**Re: 173 Huntmar Drive
Community Transportation Study (dated June 5, 2014)
Addendum #1**

This Addendum has been prepared to reflect the latest revised Concept Plan (see attached) and to respond to comments received from the City of Ottawa, dated September 9, 2014, with regard to the above-noted Community Transportation Study.

173 HUNTMAR DRIVE

**DRAWING**  
**SITE PLAN**

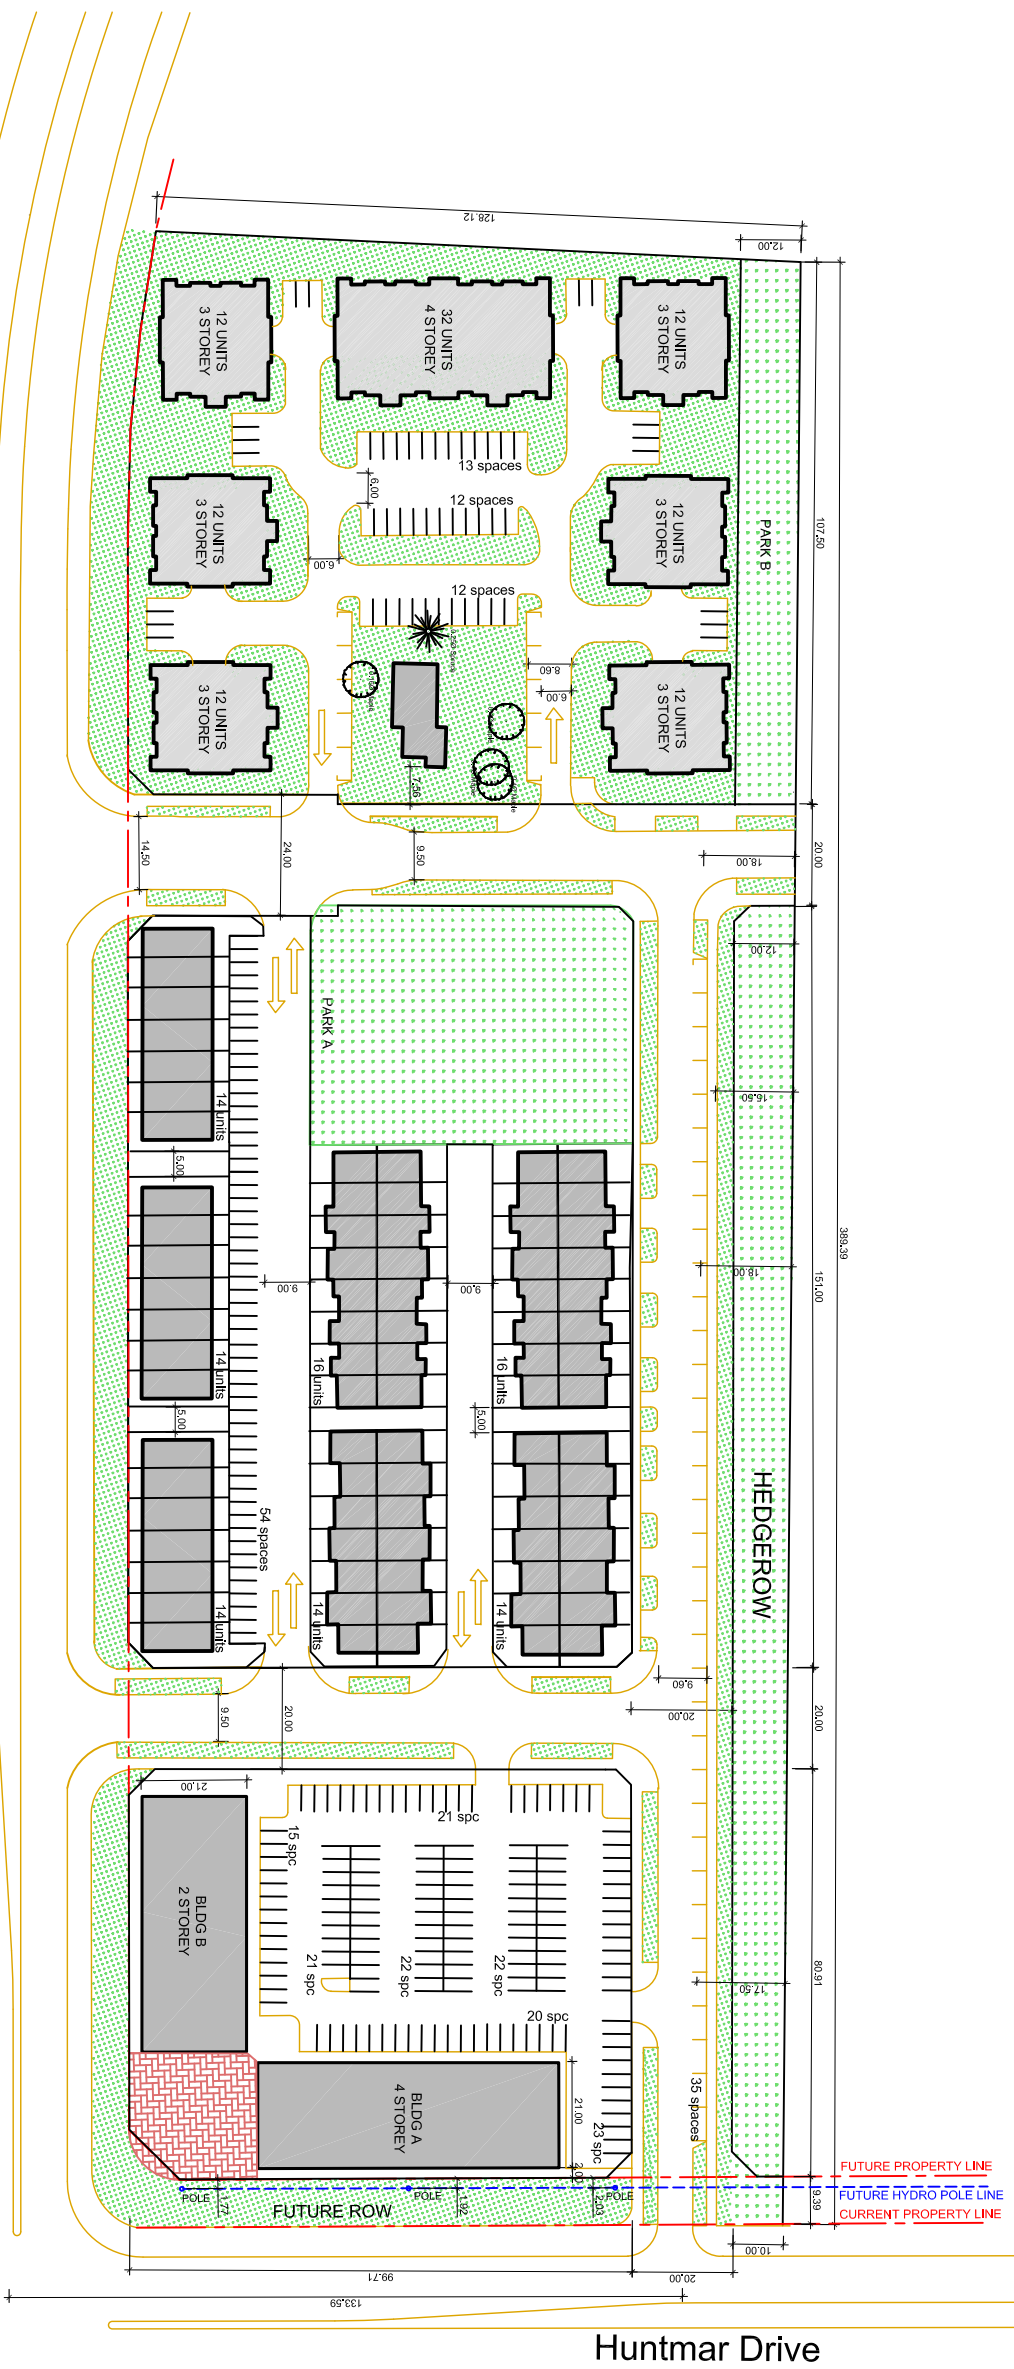
However, the proposed stacked townhome portion of the site, the City's Zoning By-Law requires visitor parking and based on the provided information, the proposed amount of visitor parking is deficient. Therefore, the proponent is seeking a By-Law variance to permit a reduced amount of provided visitor parking for the stacked townhome portion of the site.

With regard to on-site circulation, the proposed Concept Plan is laid out effectively, provided that STOP control is implemented on the minor approaches at on-site intersections and appropriate signage (e.g. Do Not Enter and One-Way, etc.) is installed where One-Way circulation is desired.

Bicycle parking is not identified on the proposed Concept Plan. Bicycle parking should be provided in well-lit areas/close to building entrances and a rate to meet By-Law requirements.

Comment 25: *Concept Plan Review pg 16. The parking requirements as presented is unclear-the report refers to "Area C" but the Concept Plan does not identify this area. It appears that parking spaces will be limited within the development particularly visitor spaces, with no available on-street parking and this should be reconsidered. For the apartment unit parking the report states the spaces will be located partially underground, does this mean that some apartment unit parking will be aboveground and if so where will they be located?*

Response 25: The reference to "Area C" in the original CTS, is in reference to the Zoning Area (i.e. Central Area, Urban/Greenbelt Area, Rural Area, etc.) where the proposed development is located. This area can be identified in Part 17 - Schedule 1 of the City's Zoning By-Law. As such, the parking rates were calculated with respect to the By-Law requirements for Area 'C'.

It should also be noted that the total amount of parking to be provided is uncertain at this stage of development. The exact amount of parking to be provided at each phase of development will be defined during the Concept Plan Application process. In addition to the amount of parking, the location of apartment unit parking will be defined during the Site Plan Application process.
